M5 Junction 10 Improvements Scheme

**Applicant Response to Relevant Representations on
Changes**

TR010063 - APP 9.91

Applicant Response to Relevant Representations on Changes

Project Title	M5 Junction 10 Improvements Scheme		
Drawing Title	WORKS PLANS REGULATION 5(2)(j) SHEET 12 OF 16		
Drawing Number	TR010063/APP/2.4		
Original Size	A1	Scale: 1:1250	Project Ref. No: 5228847
Sheet	12 of 16	Rev:	C03

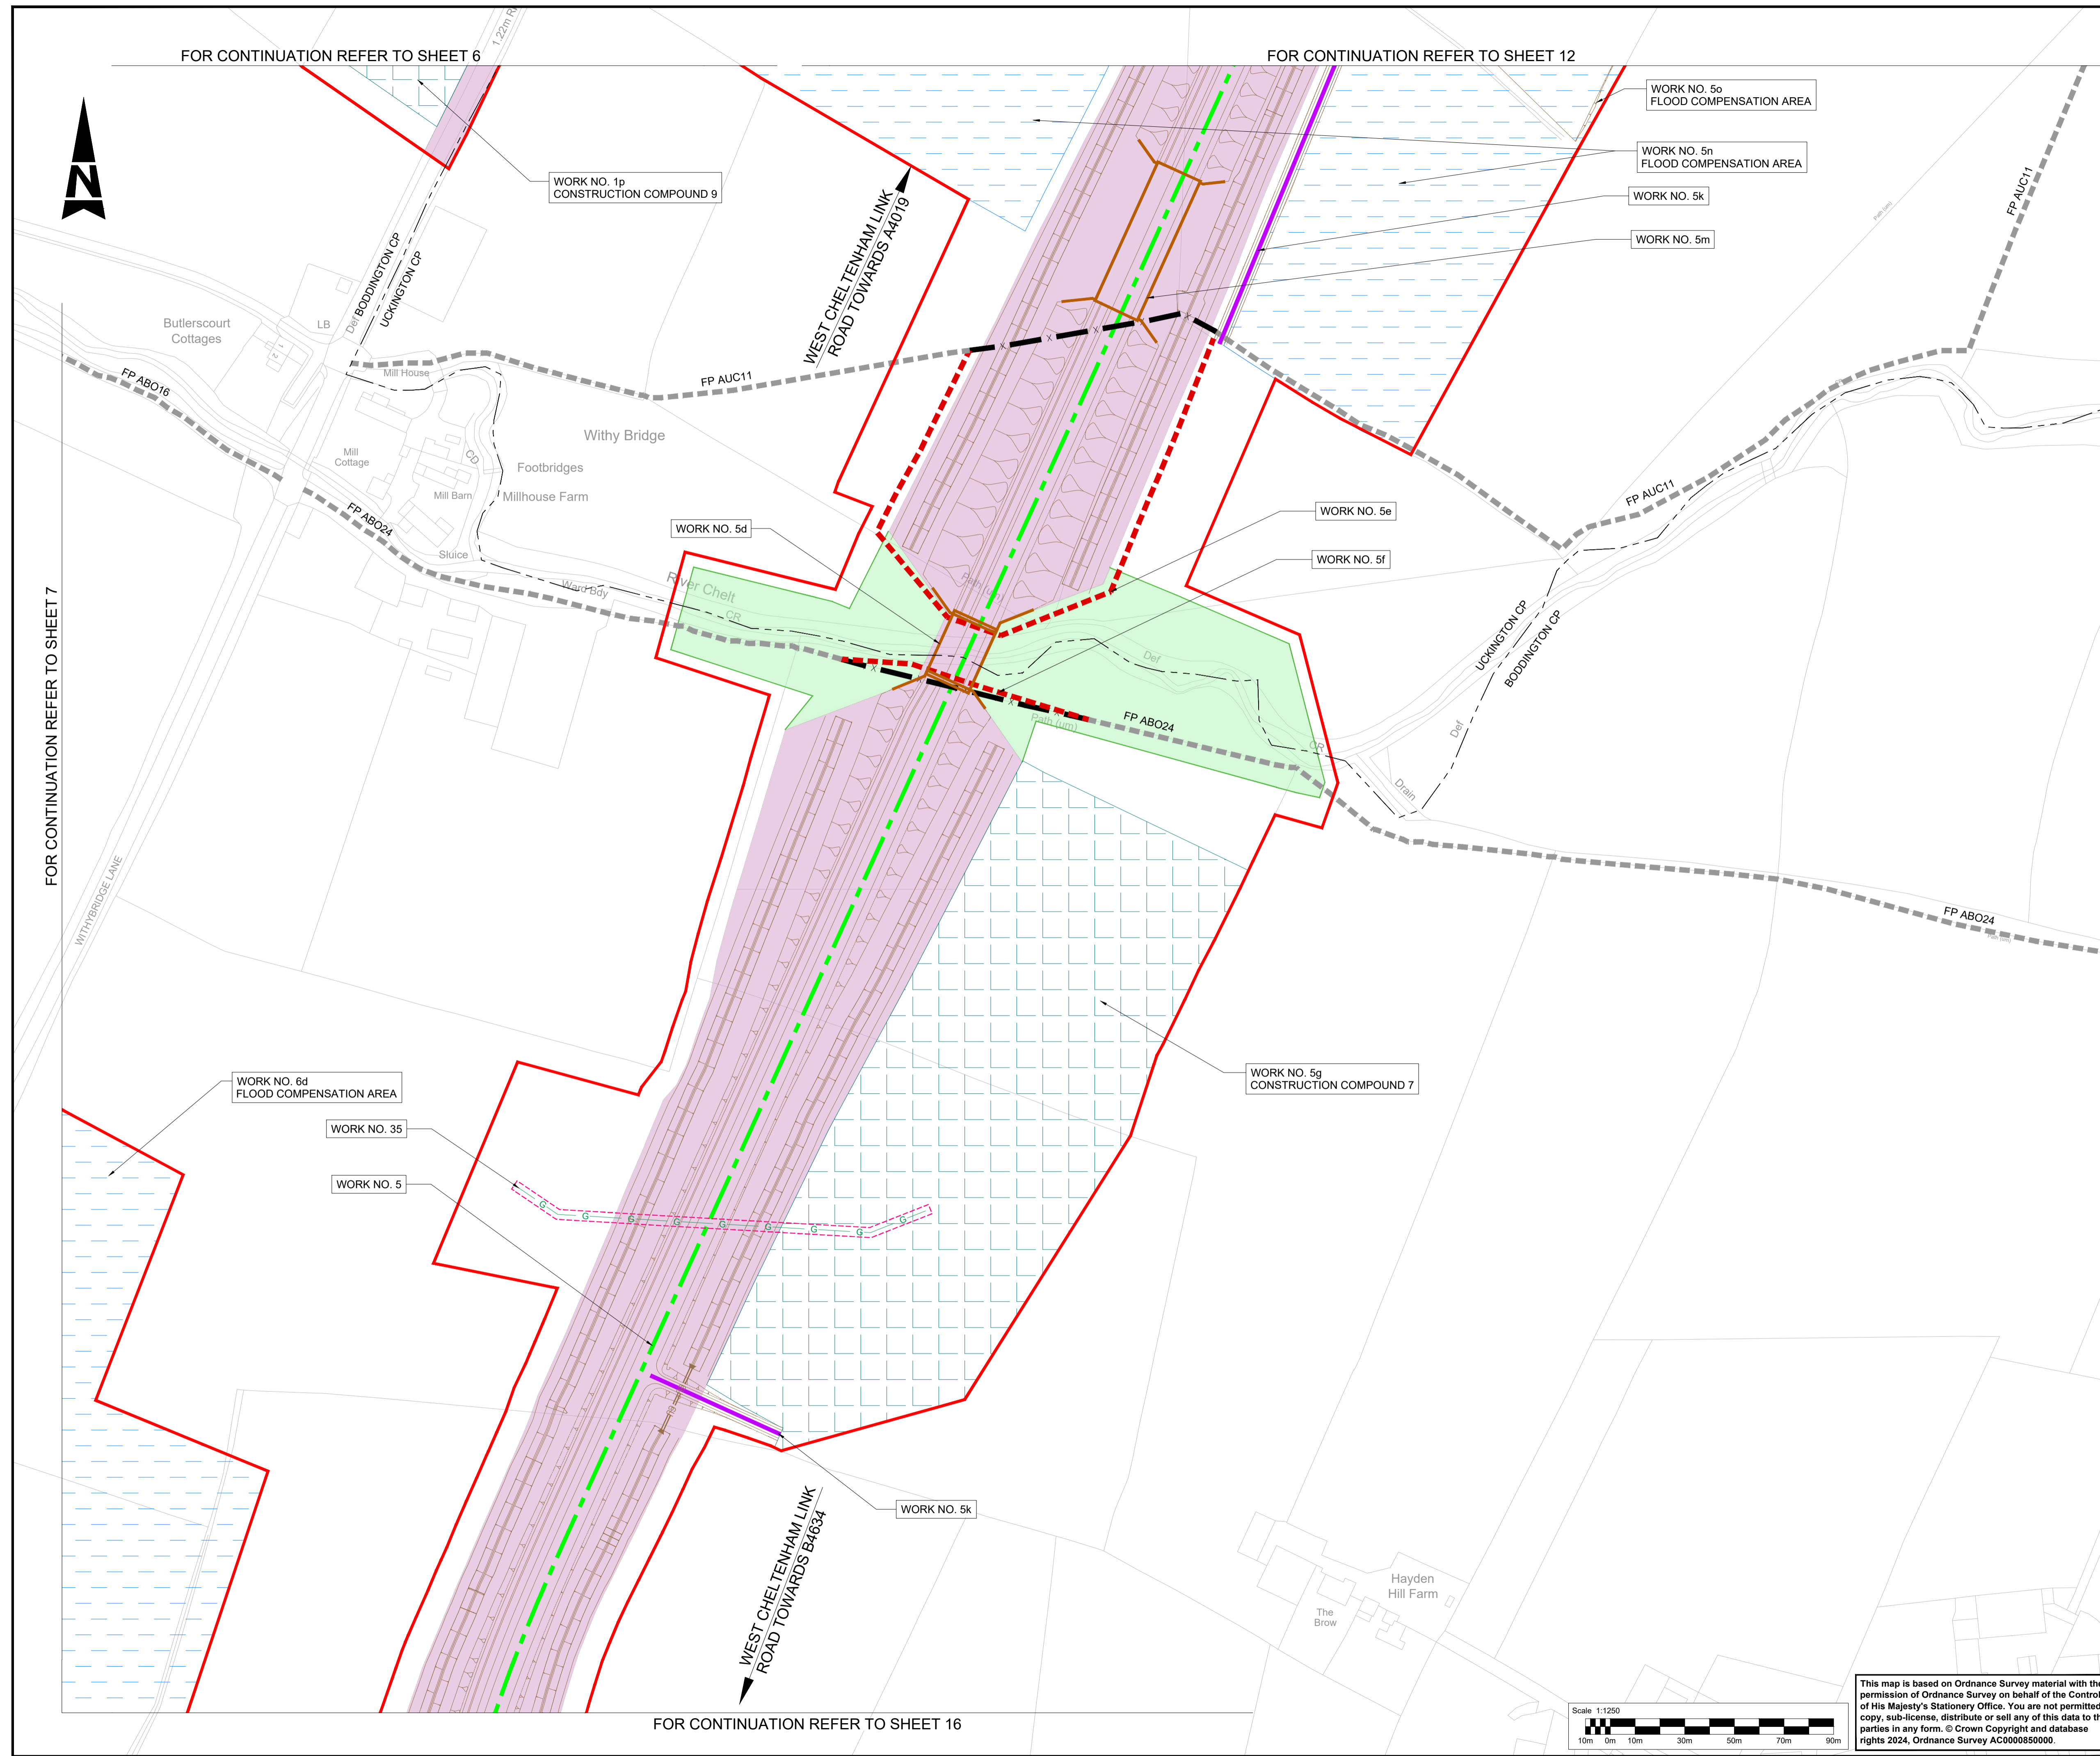
Reference No.	Interested Parties Response	Applicant Response
		<p>The DCO limits (redline boundary) have been confirmed, are fixed and are shown on the DCO Plans (see Sheet 12 of the Land Plans REP5-002). The Plan confirms that the redline boundary follows the front of the properties at Church view.</p>
045-04	<p>Furthermore details of the proposal in front of Church View is unclear, as per the extract of the scheme plan below:</p> 	<p>The proposal, as detailed within the DCO application, is to provide access to the existing road in front of Church View via a proposed new side road which links to the proposed West Cheltenham Link Road by means of a priority junction.</p> <p>Works will be undertaken in this area as shown in Works Plans 12 TR010063/APP/2.4.</p> <p>These works include:</p> <p>Work No.5a: the construction of a service road linking properties south of the A4019 (Tewkesbury Road) and Cooks Lane (the need for resurfacing of the existing layby will be considered during detailed design).</p> <p>Work No. 5k: the construction of new or altered private means of access (connection of existing access track to Work no 5a described above)</p> <p>Work No.4k: the construction of an environmental barrier approximately 160 metres in length south of the A4019 (Tewkesbury Road) adjacent to Cooks Lane</p> <p>Work No. 15: the diversion of 7090 metres of water pipeline at the location shown on sheets 5, 12, 13 and 14 of the works plans.</p> <p>Work No. 30: the diversion of 122 metres of telecommunication cable and associated apparatus and equipment at the location shown on sheet 12 of the works plans.</p>

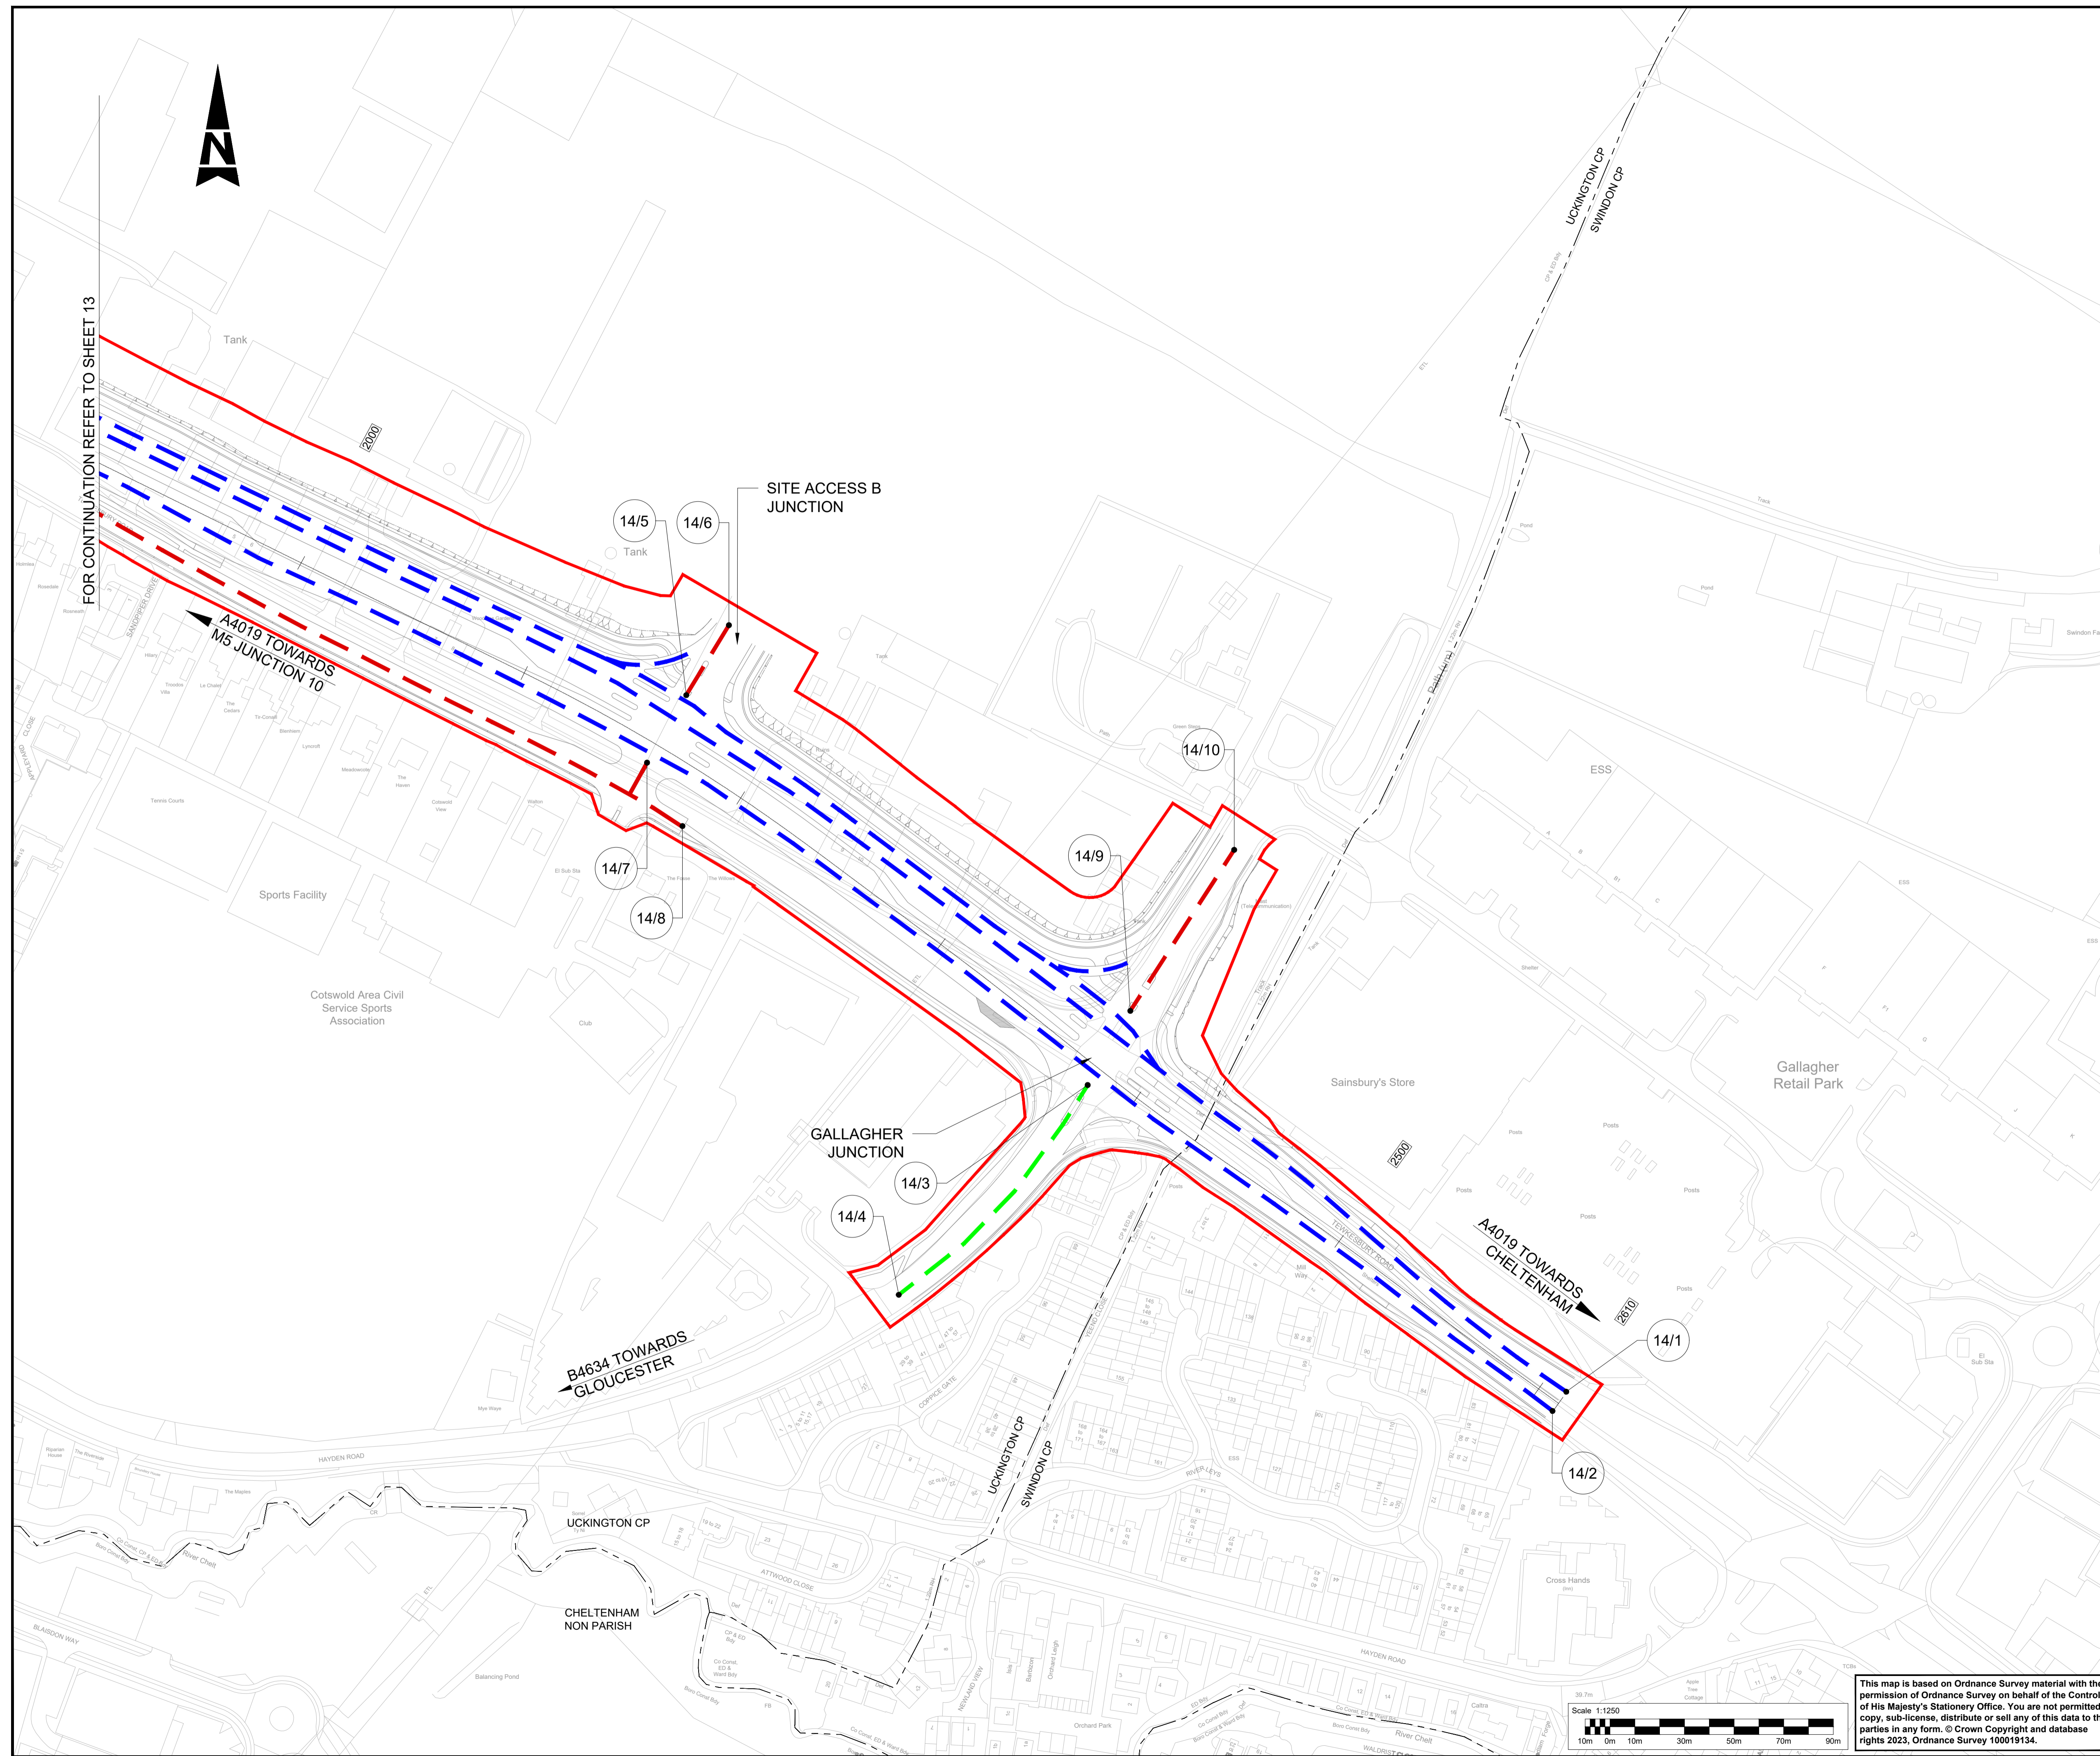
Reference No.	Interested Parties Response	Applicant Response
	<p>Clarification is required on these matters.</p>	<p>highway and therefore the long term maintenance will continue to be the responsibility of GCC. The Classification of Roads Plans [ref], sheet 12, show that the A4019 mainline will be classified as an A-Road, with the service road running parallel with the A4019 classified as “unclassified”. This position is secured in the dDCO under Article 14.</p> 
045-06	<p>The Noise and Vibration chapter of the PIER confirms that a 2m reflective noise barrier will be located adjacent to the properties on Church View but it is unclear from the scheme plan where this will be located. The term ‘reflective’ is also concerning because this could create significant glare and light pollution for the properties along Church View. It should be noted that habitable rooms are located on the front façade of properties which will look toward the noise barrier. In</p>	<p>It is not clear from the comments made which version of the NPPF is being referenced. Based on the subject matter raised, in this instance, the Applicant has assumed that the interested party is referring to the 2023 NPPF and has responded on that basis.</p> <p>The information provided below reflects the details reported in the Environmental Statement (ES), and supporting documents (including the</p>
